I wish to express my support for the principle of the proposed development. However, as a resident of Brougham Road, I have a number of concerns that I believe should be addressed, particularly in relation to parking provision, road safety, and supporting infrastructure.

Parking Capacity Surveys: On Street Parking Availability

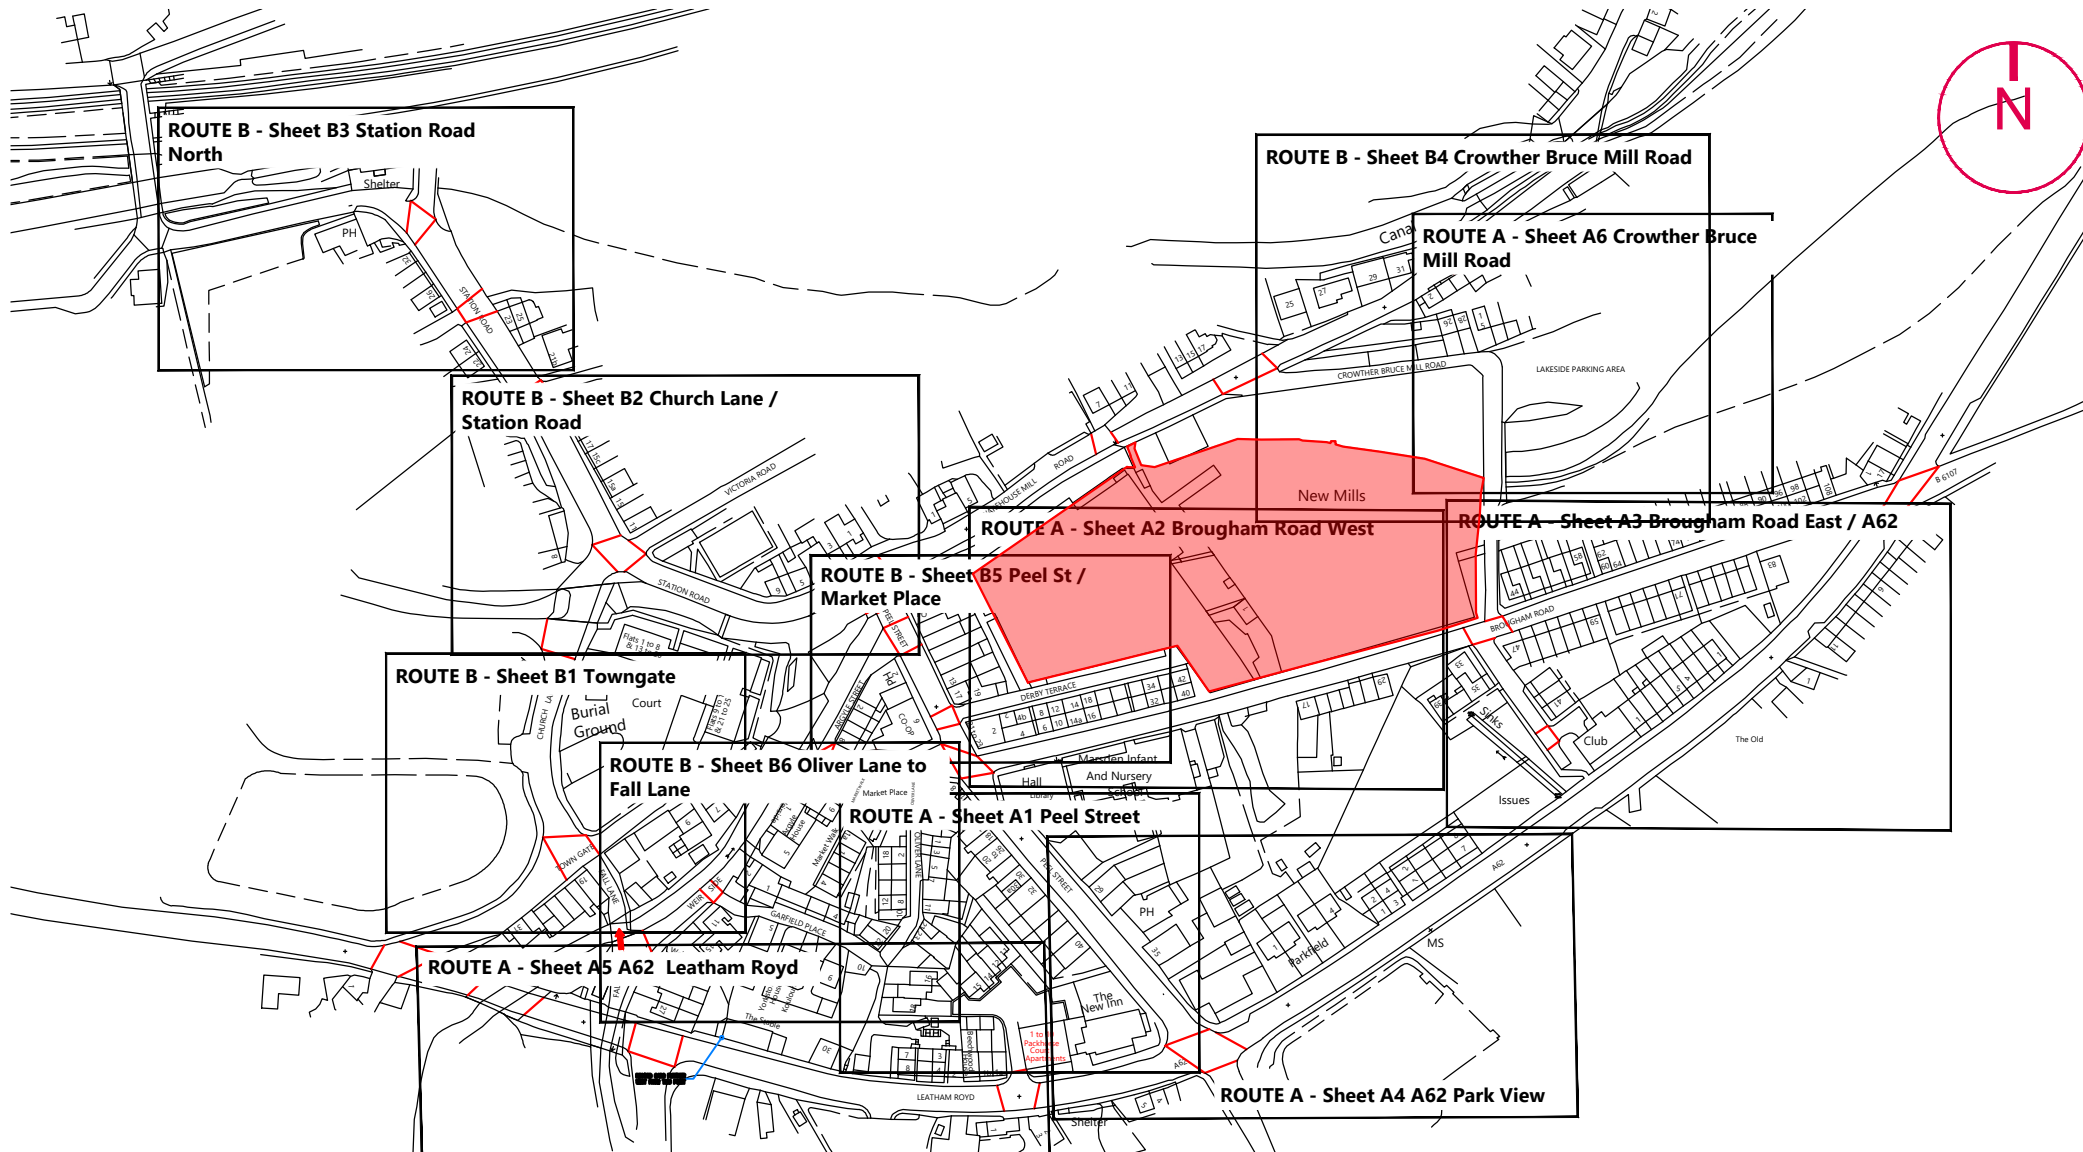
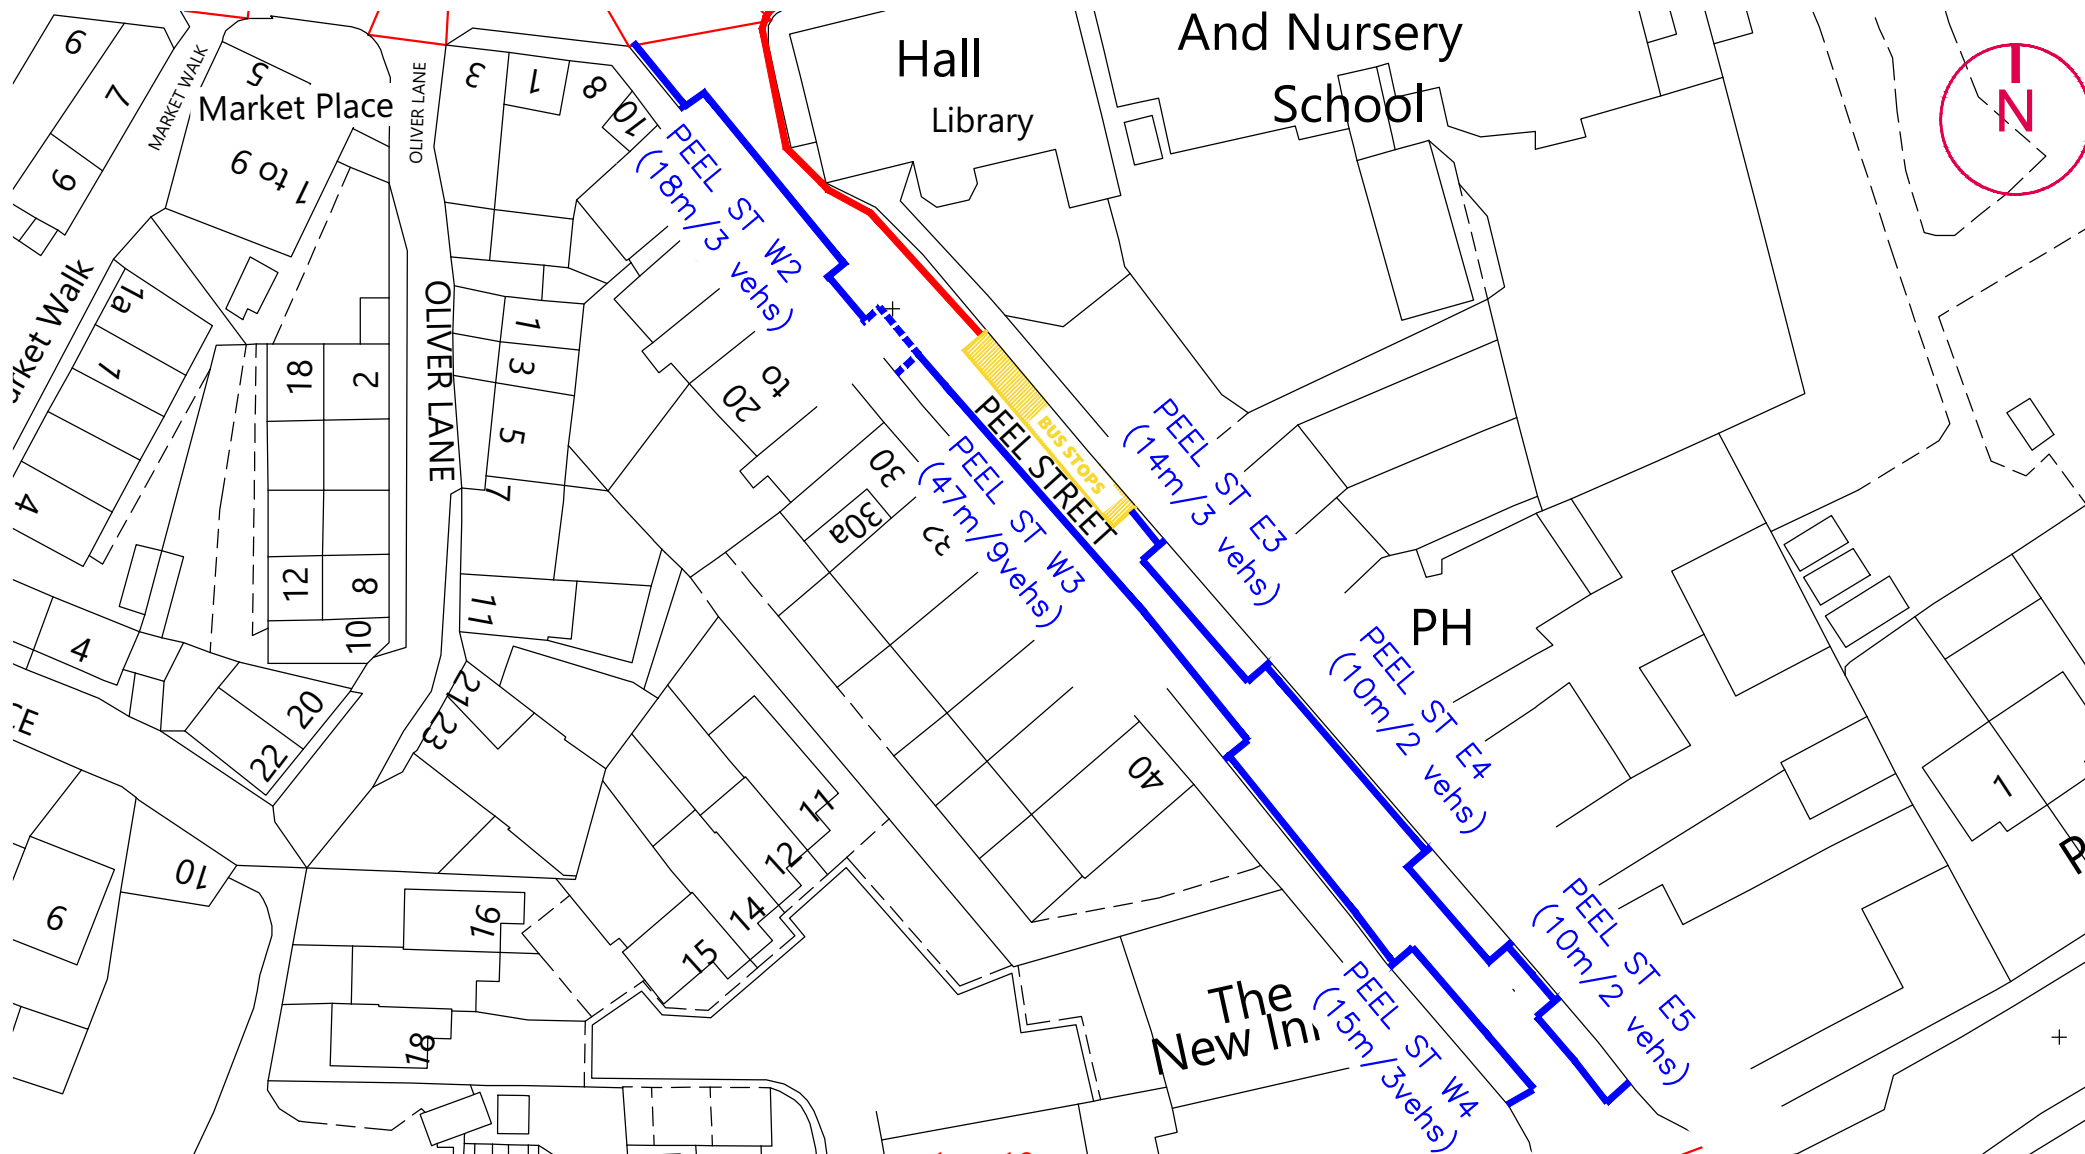
Brougham Road already experiences significant pressure on on-street parking. This has increased in recent years due to growing families and multi-vehicle households, with many properties accommodating two or more cars. As a result, parking availability is limited, particularly during evenings and weekends.

Without sufficient off-street provision, the proposed development is likely to increase demand further, leading to greater congestion, unsafe parking (including on pavements or near junctions), and restricted access for emergency and service vehicles.

Reassesses the adequacy of parking provision

Explores additional parking solutions where feasible, including use of rear land
